File Ref: EXT/2022/0009

**SSD-35962232- Burrows Road Multi-level Warehouse, St Peters**

Thank you for providing Council with the opportunity to comment on the development proposal for a multi-level warehouse at 1-3 Burrows Road, Alexandria.

Figure 7.4. Alexandra Canal - PMF Flood Extent and Depths

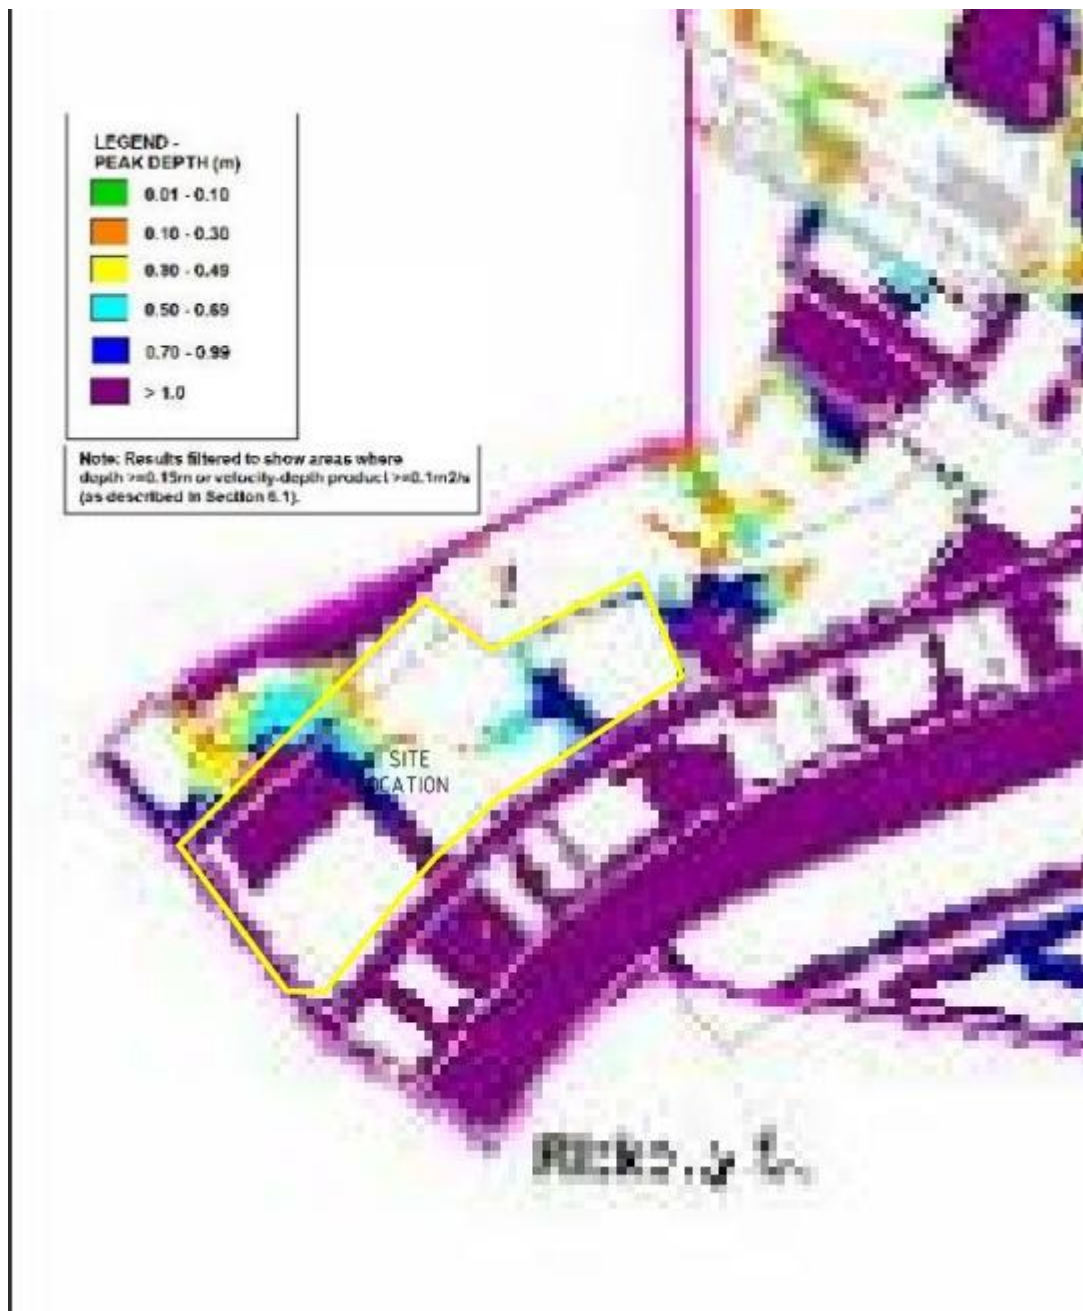
Council does not agree with the the conclusion in Section 7 (Flooding and Overland flow) of the Civil Engineering Report by Costin ROE where it states that with reference to Figures 7.4 & 7.5, that the significant flooding shown on these maps (greater than 1m within the property) is a function of the modelling. In addition, Council strongly disagrees with the overall conclusion in Section 7.5 that the site is not subject to flooding and as such no detailed modelling or flood impact assessment is necessary.

It is recommended that Pre and Post development 2D flood modelling be provided to confirm that there are no adverse impacts or loss of flood storage resulting from the development for a range of storm events. In addition, it must be established that the intersection of Burrows Road/Burrows Road South/Ricketty St/Canal Road is not further adversely impacted by additional flooding during major and minor storms events including the 1 on 2 year storm event.

A FRMR must be prepared for the site and detail how the development (floor levels) will be protected from flooding and how the flood risk will be managed. In addition, a flood evacuation and response plan must be provided taking in to account the PMF.
